25 November 2014

**RE: ST CATHERINE'S SCHOOL MASTER PLAN (SSD 6339)
29 ALBION STREET, WAVERLEY**

Submission to Department of Planning and Environment St Catherine's School Master Plan

Figure 17 – Existing vehicular and pedestrian entry points (source: Mayoh Architects, A.MP.007)

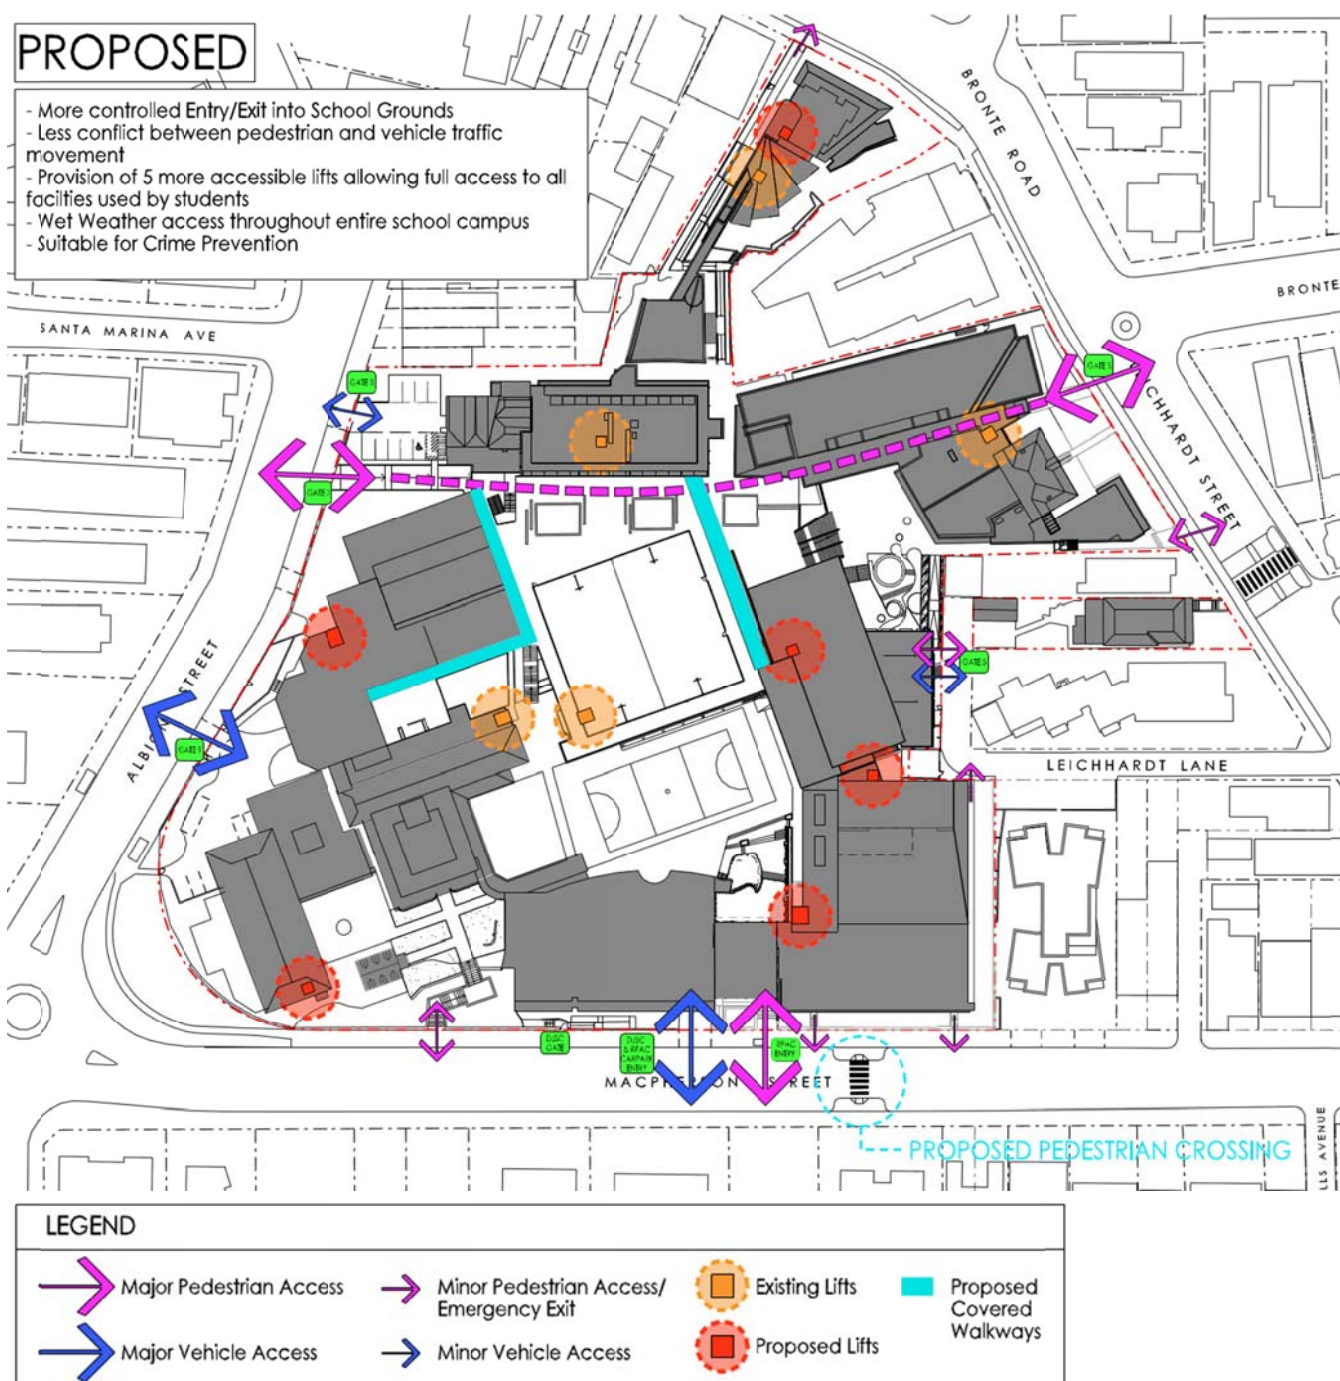
The proposed changes to pedestrian access and management should be detailed and assessed. Changes to existing pedestrian access arrangement will have flow on impacts for traffic, vehicular access and parking at all of the sites frontages. The changes to pedestrian access arrangements should be detailed and incorporated into traffic, vehicular access and parking reports and assessments.

**Figure 25 – RPAC landscape East Elevation to 4 Macpherson Street and Section (source: Silk Consulting, DA-L-03)**

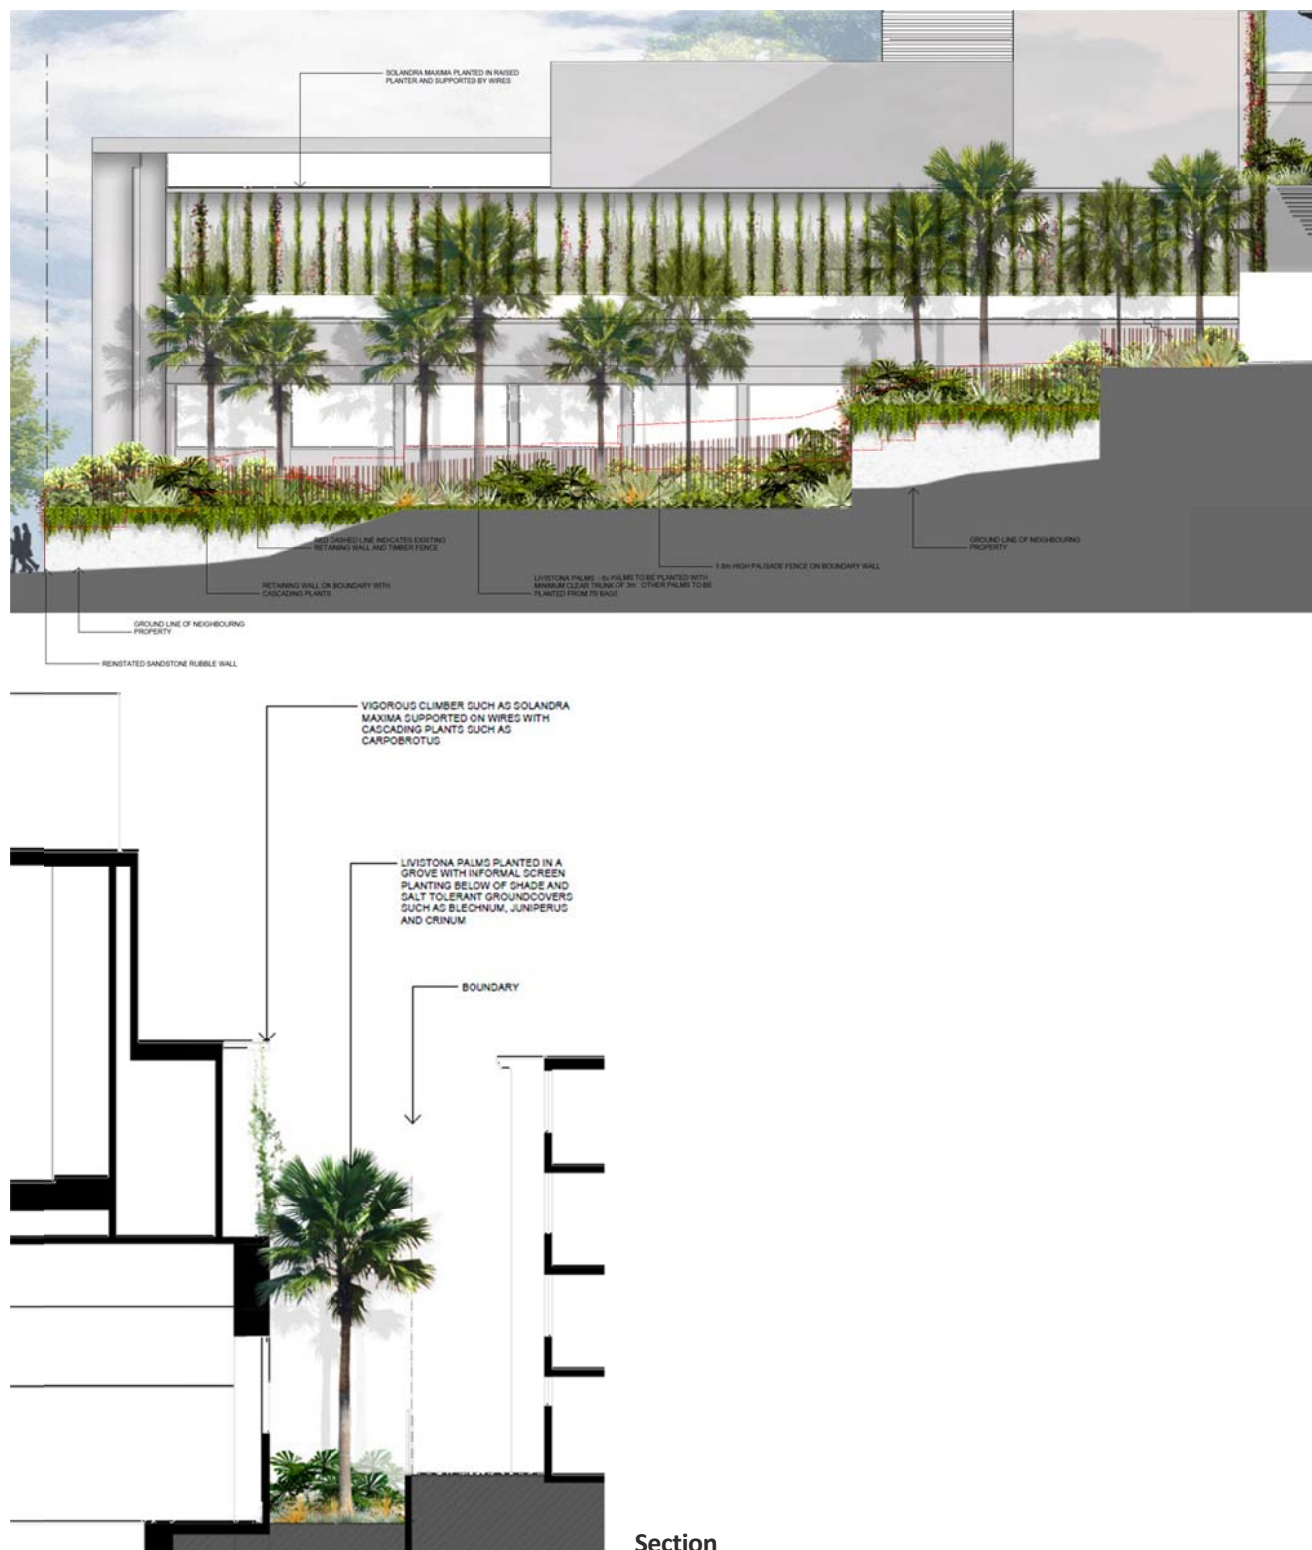
It is recommended that the boundary planting and stone walls be generally retained and enhanced. Particular attention needs to be given to the adjacency issues with the adjoining residential flat building to the site's east at 4 MacPherson Street. The Council's PreDA flagged this issue but it is not apparent in the plans that it has been resolved. The residential flat building's land is undulating and it is appropriate that the proposed side fencing and

landscaping within the school carefully consider the boundary treatment along this length of the site to ensure there is consistent fencing/landscaping, rather than some high points and some low points in the fence.

The proposed RPAC building incorporates considerable glazing to the south elevation fronting MacPherson Street and east elevation adjacent to the residential flat building at 4 MacPherson Street. As the RPAC building is surrounded by low and medium density residential uses, consideration should be given to the amount of light spill from the proposed building into adjacent low and medium density residential areas. Of particular concern is the east elevation windows to the aquatic centre, which may have considerable light spill impacts that will undermine the residential amenity of adjacent units, particularly during early morning and evening hours.

TRAFFIC MANAGEMENT AND PARKING

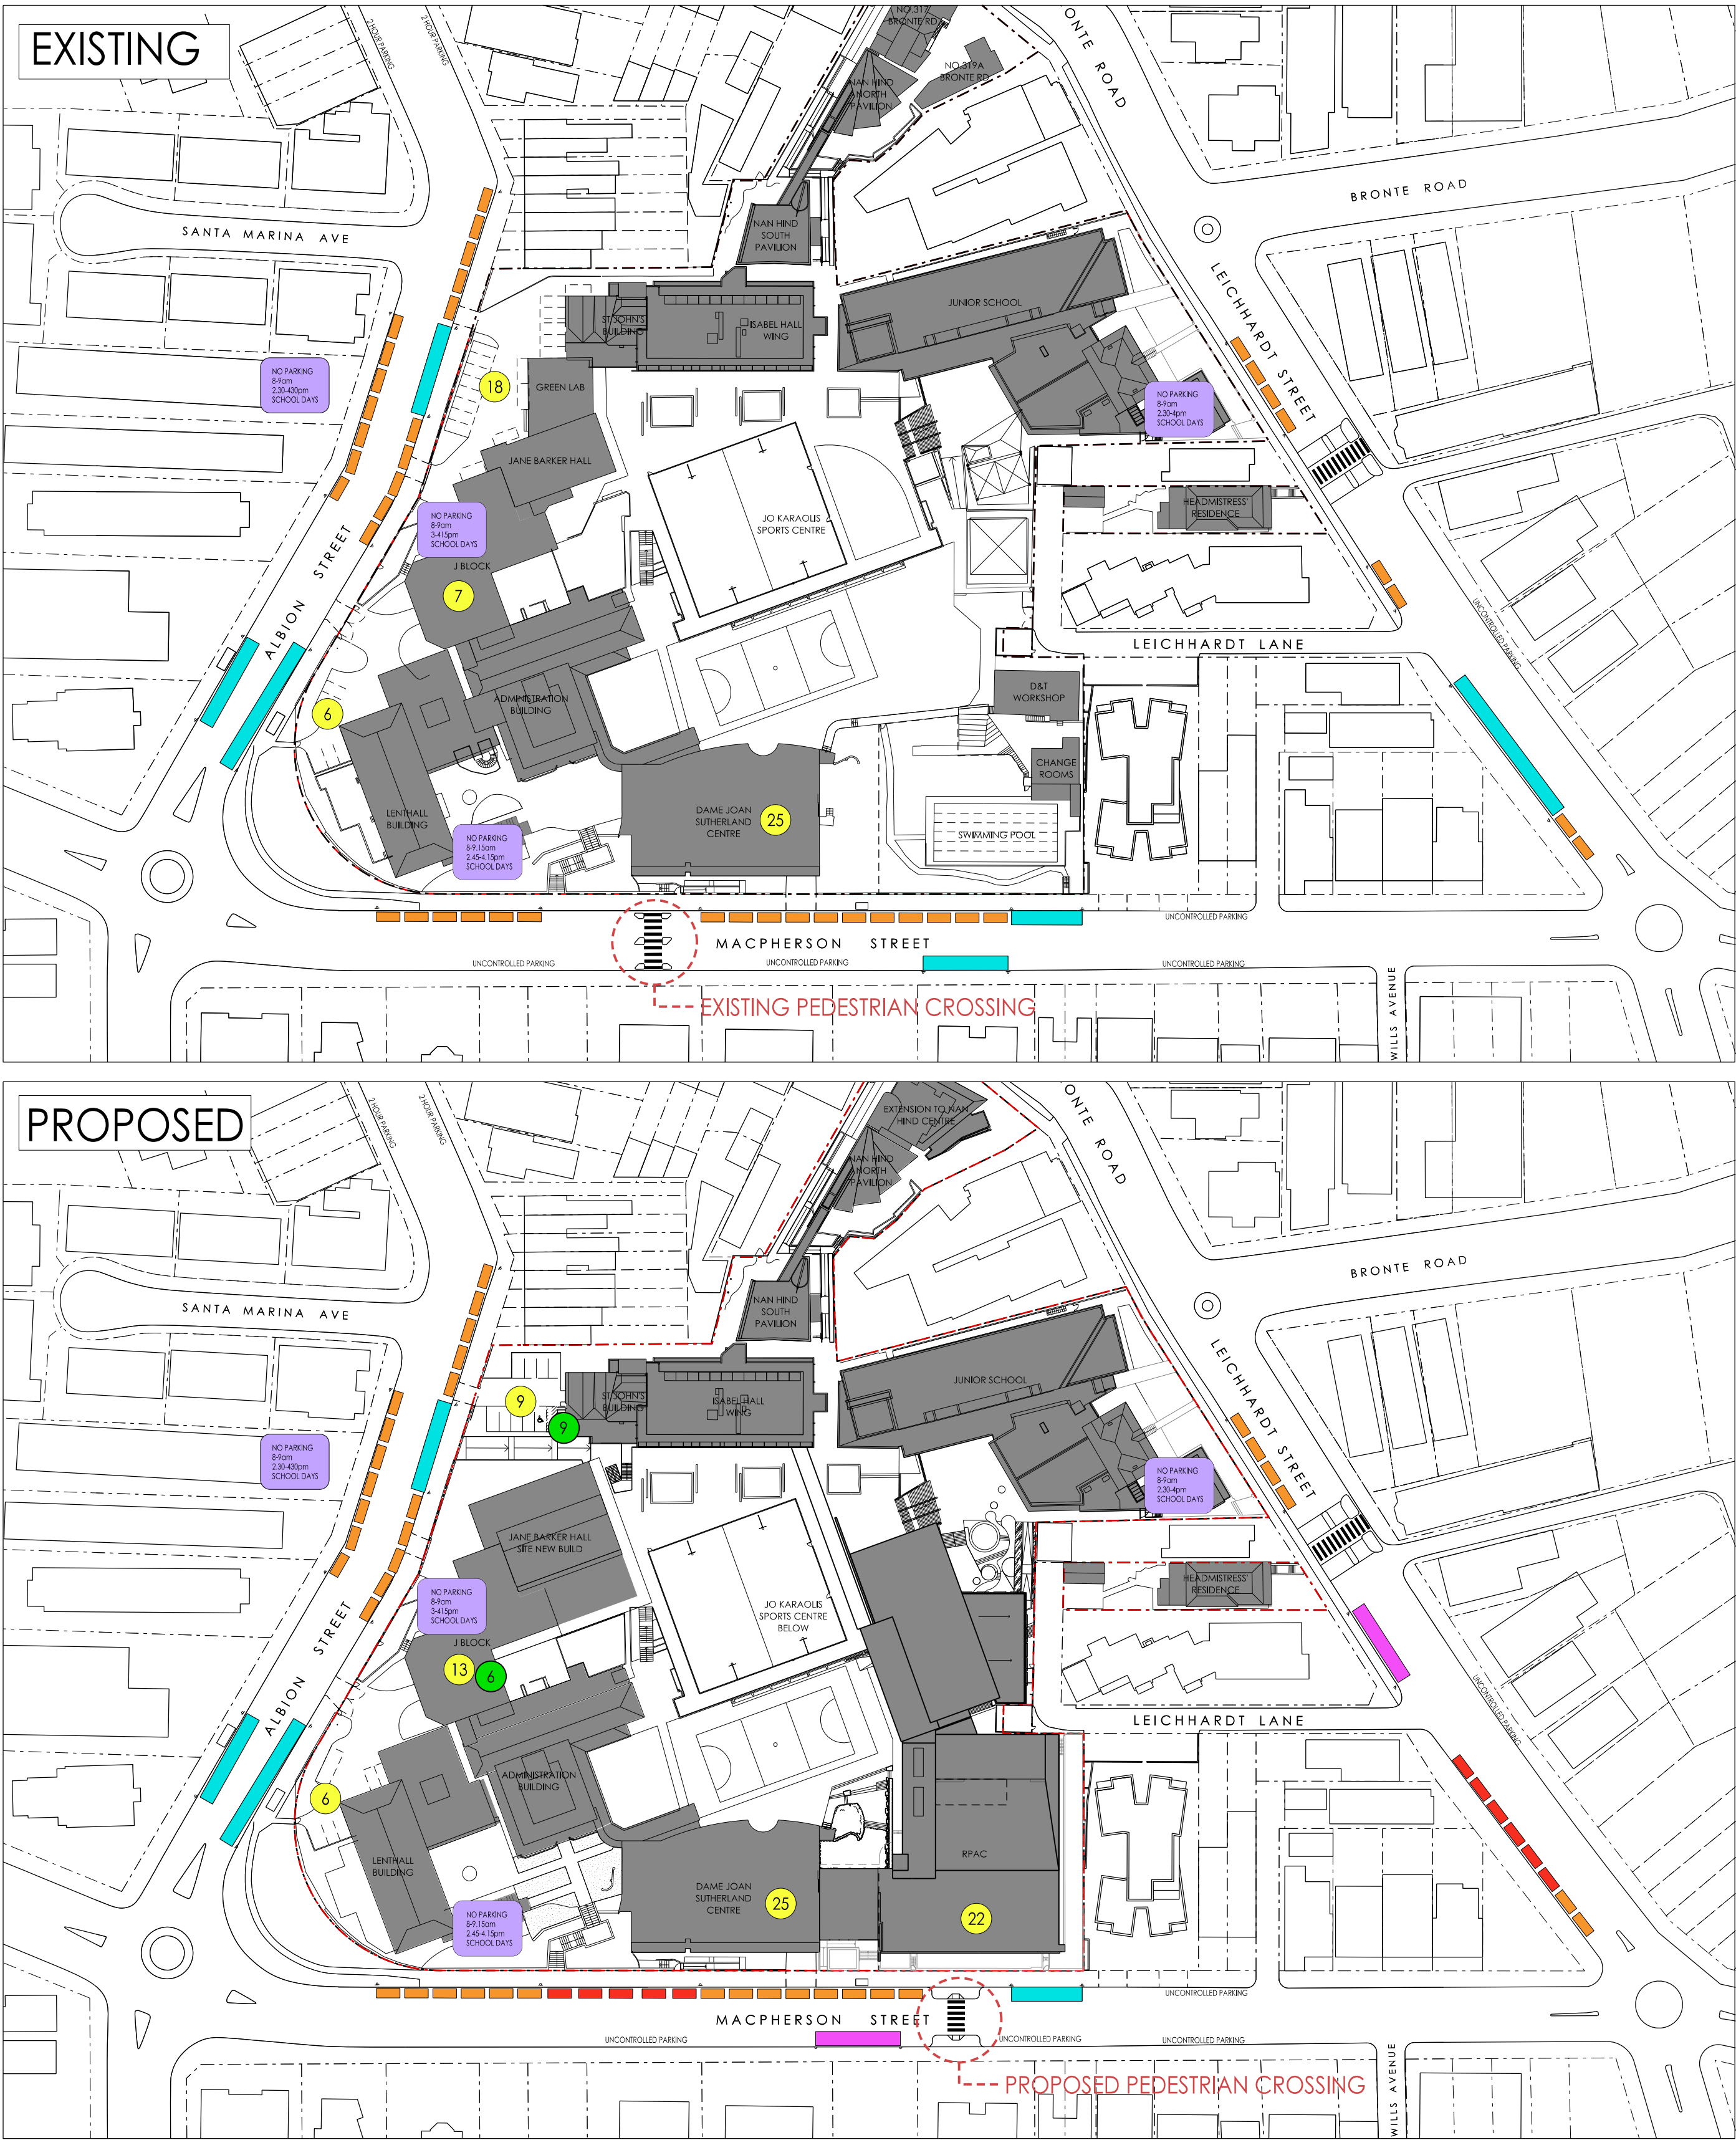
To account for the significant impacts on traffic and parking within the vicinity of the site, Master Plan should be amended to provide a substantial amount of additional on-site parking, for example a minimum of 200 car spaces – currently only 19 extra car spaces are proposed in addition to the existing 56 car spaces. This is essential due to, but not limited by, the:

The development of the RPAC should be dependent on providing the additional parking, that is, the parking should be physically provided with the first stage of development.
